Town & Country Planning Act 1990 (as amended)
Town and Country Planning (Development Management Procedure) (England) Order 2015
Approval of details reserved by condition imposed under R/269/15/PL relating to condition 11-
surface water drainage.
Fleur De Lis Station Road, Rustington,

Arun District Council have decided to **REFUSE details reserved by condition for the following reasons:**

Scale: 1:125	Paper Size: A1	Date: JUNE 2017	Drawn By: JH	Checked By: CH
Project No. RRL012	Drawing No. 505	Revision: P4

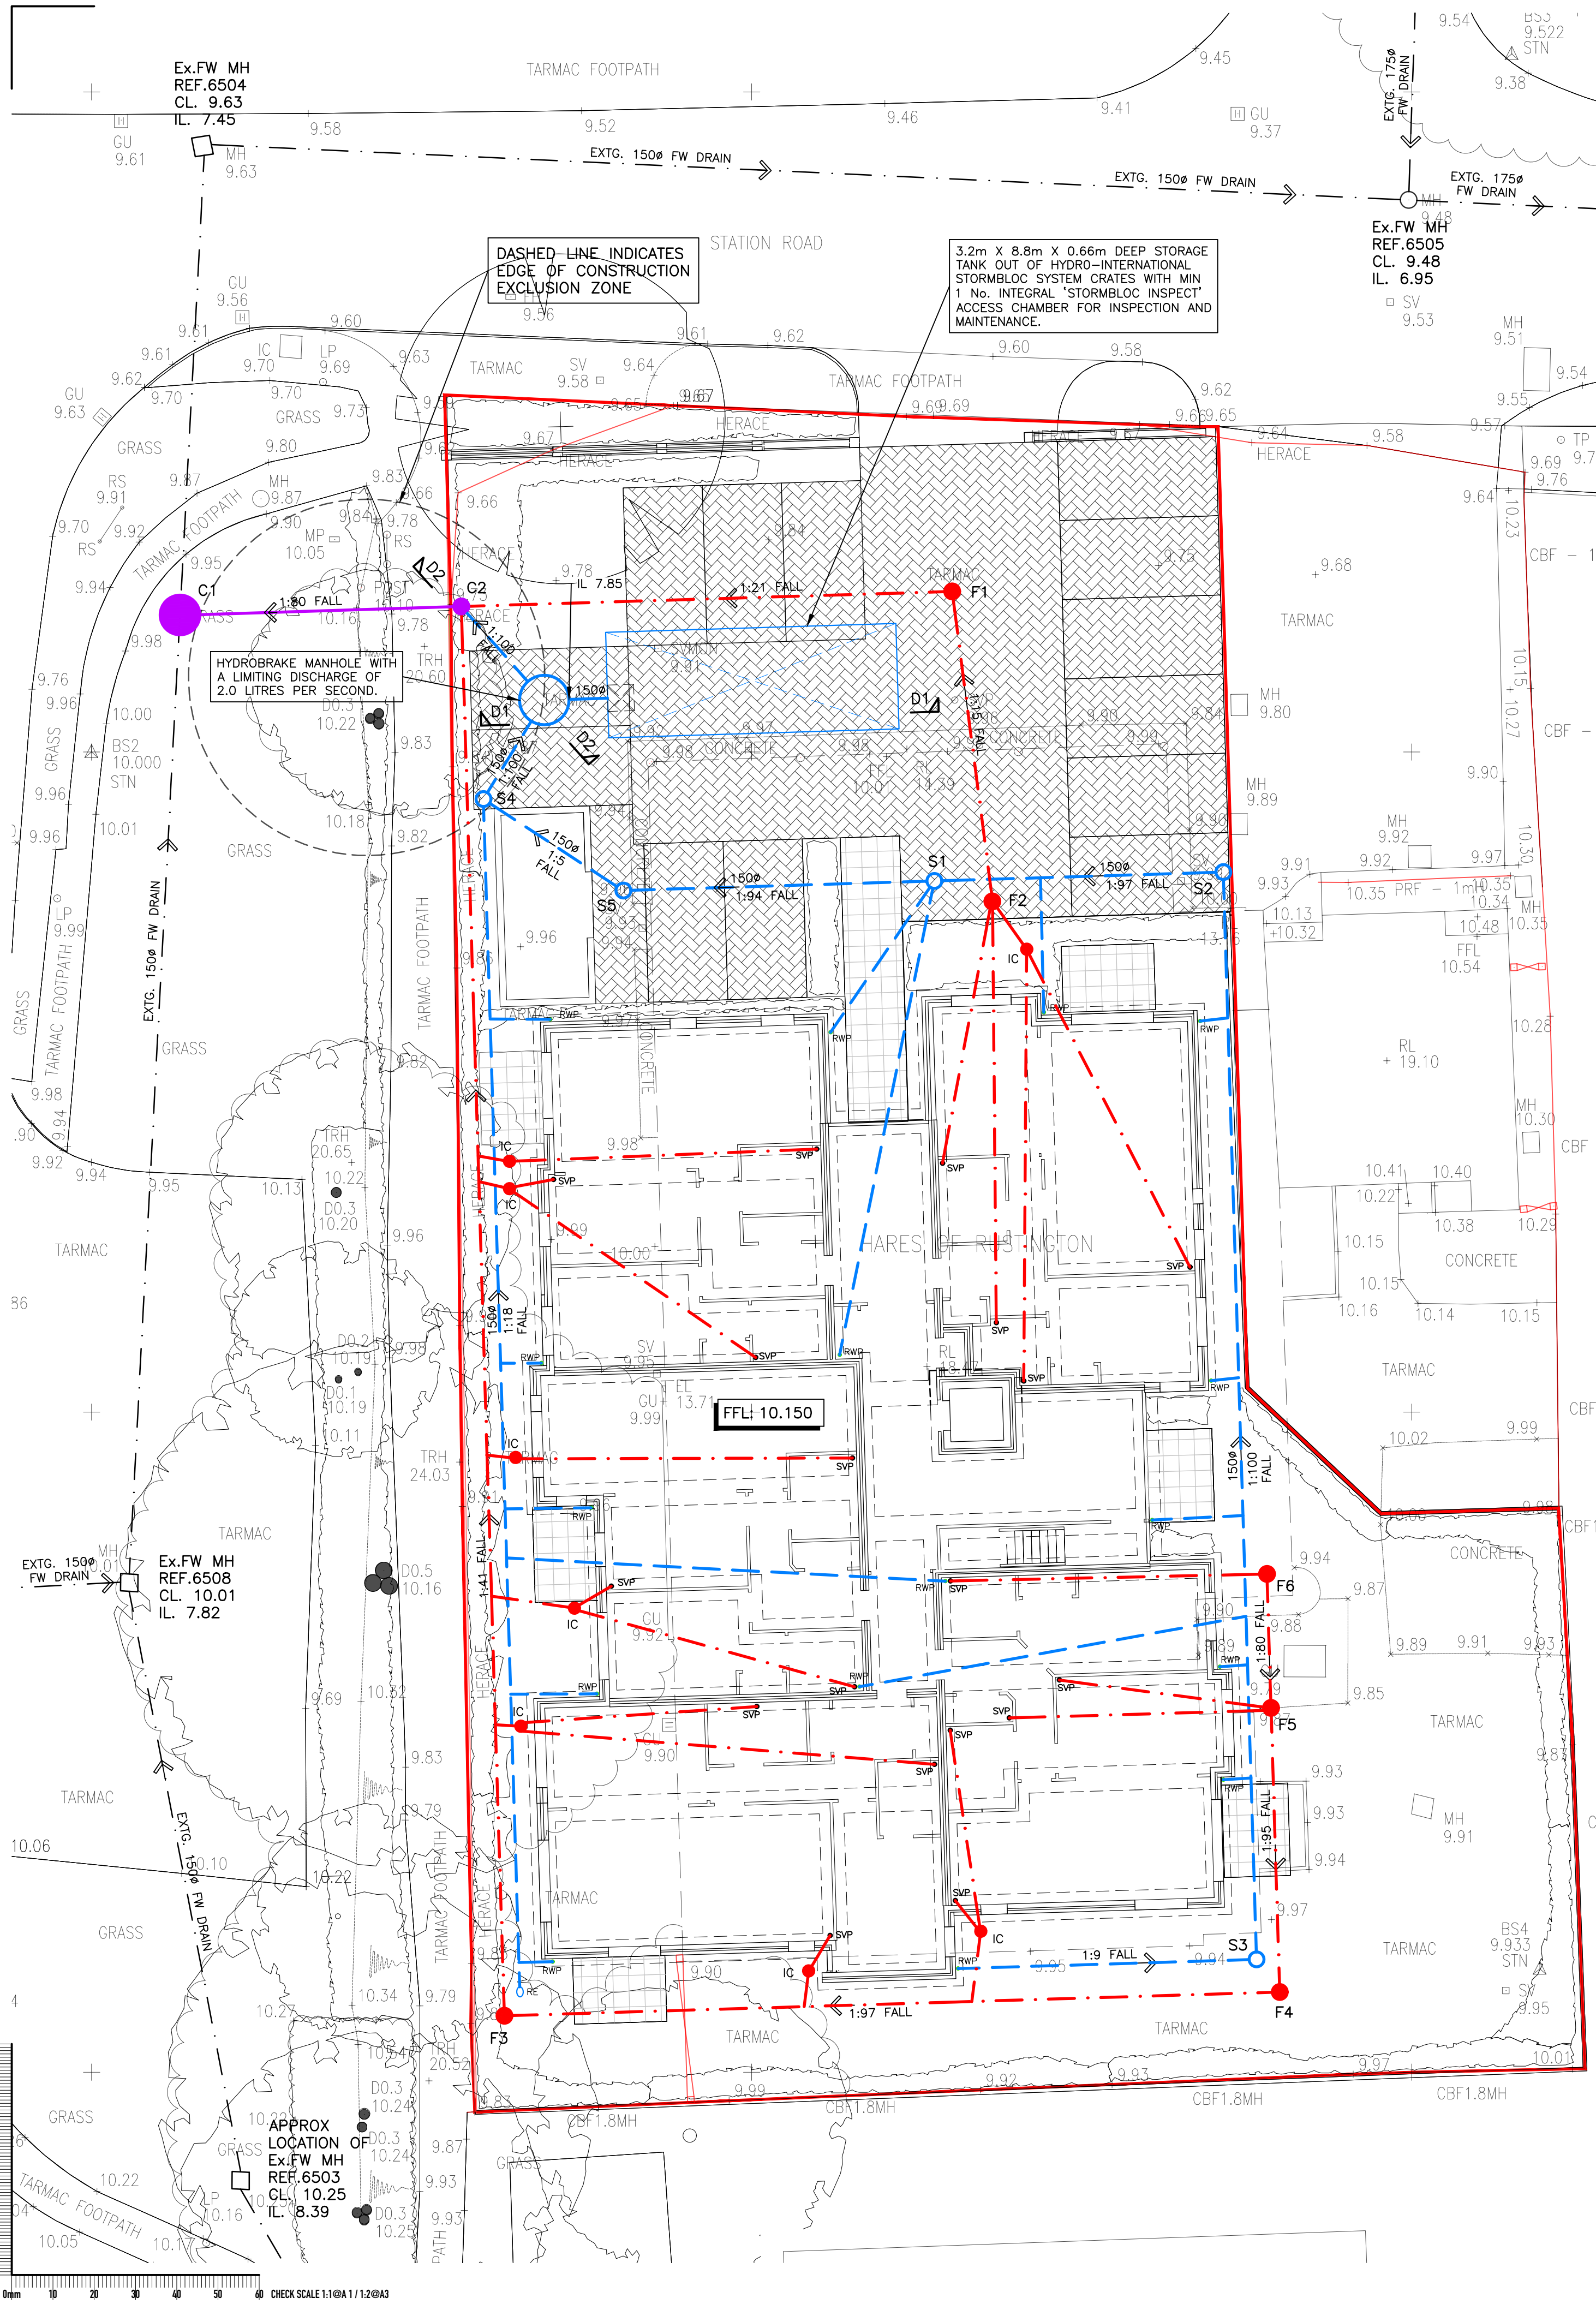
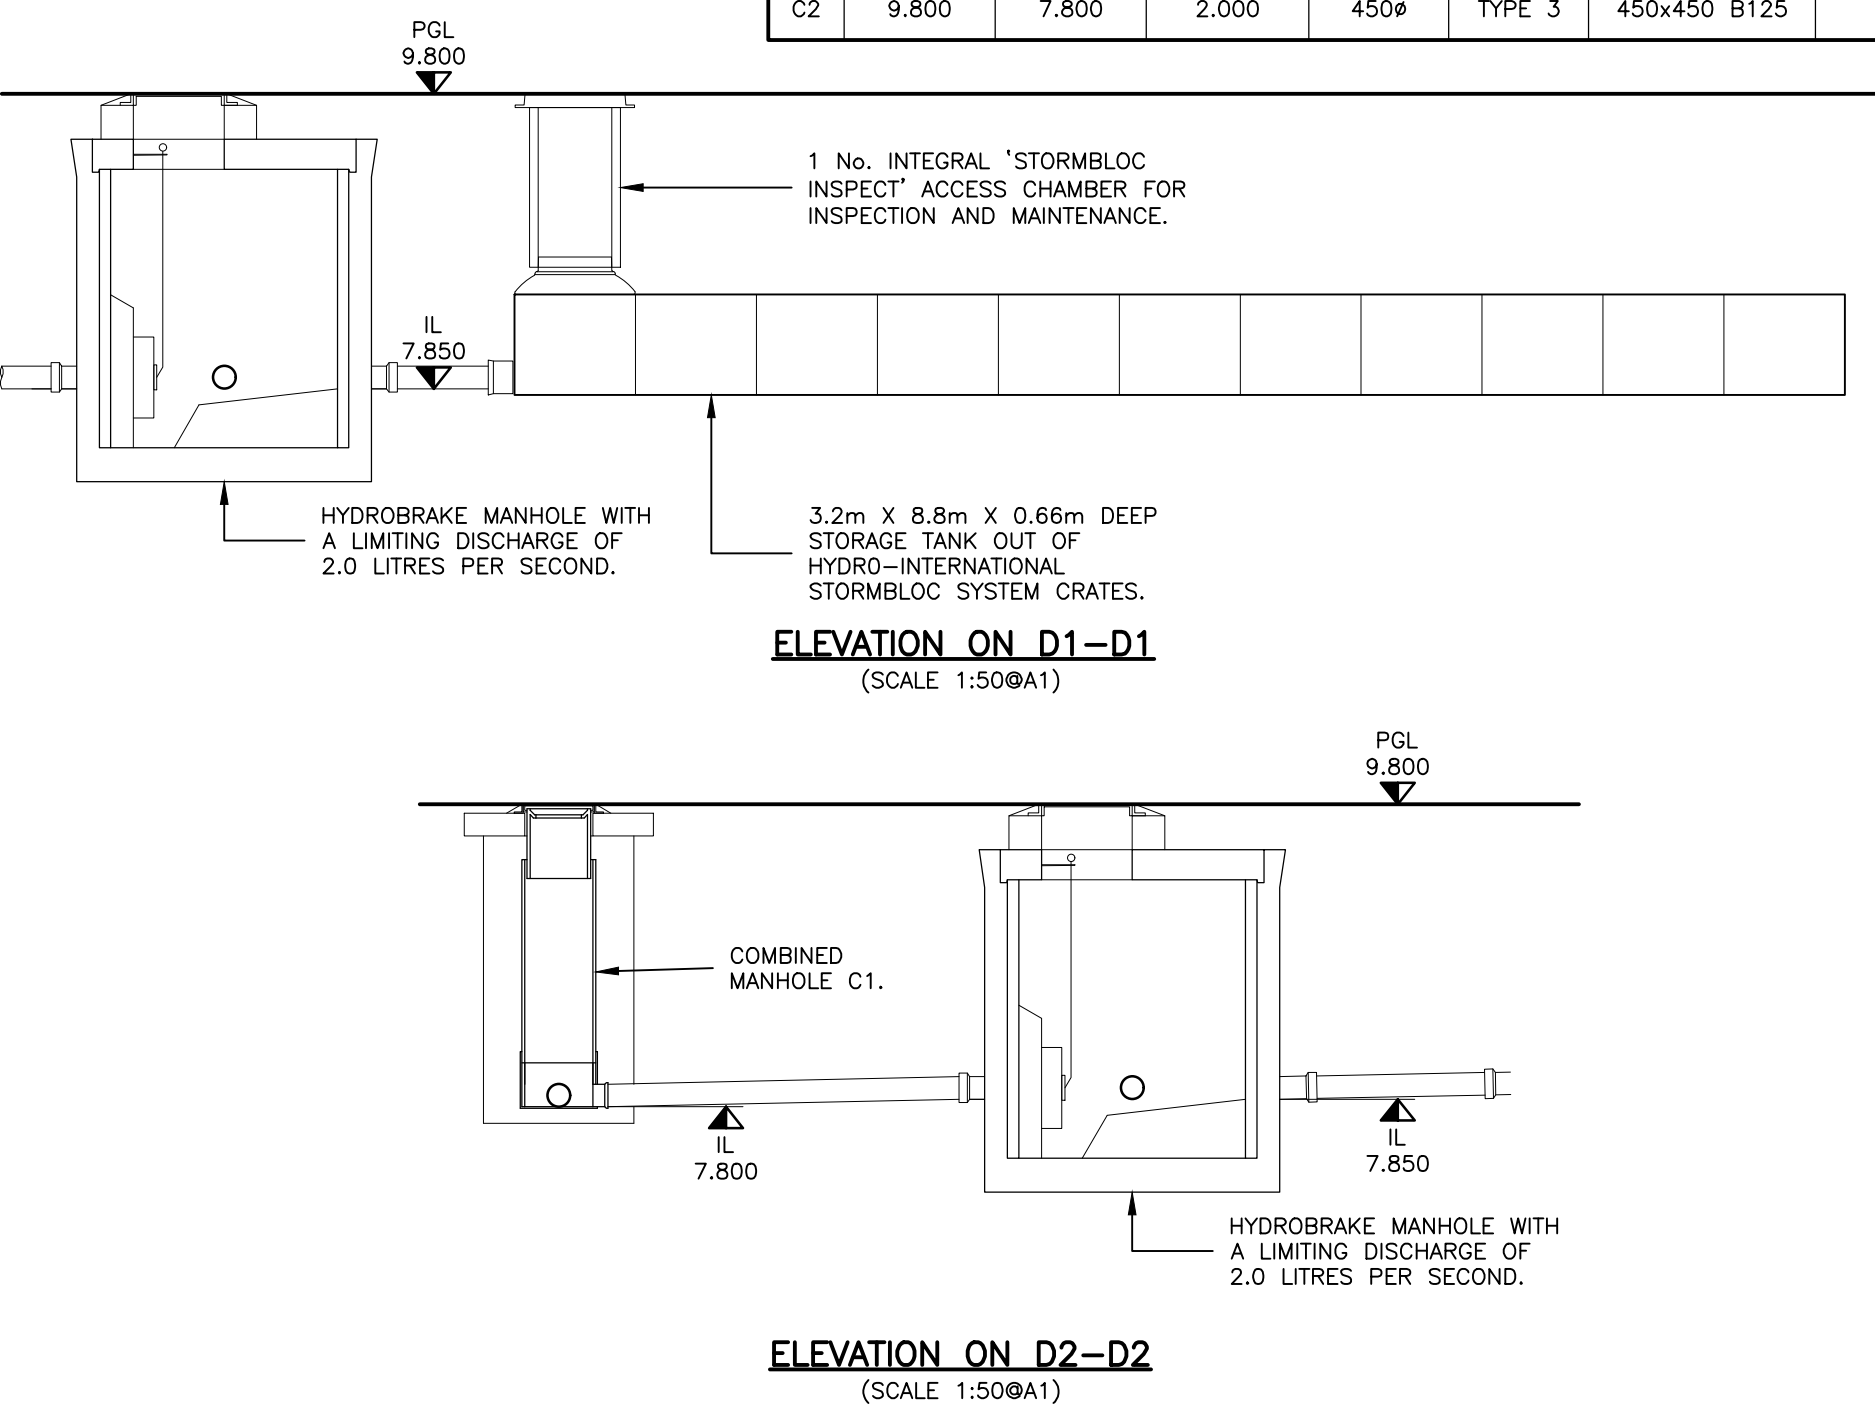
Discharging to a foul sewer should be removed from the proposal. in line with Building Regulations and CIRIA the Engineer would like you to follow the hierarchy for surface water drainage disposal. This has not been done. Infiltration testing is required to show if it is possible to infiltrate more surface water. No neighbouring sites are in true close proximity to the site.
docdeci
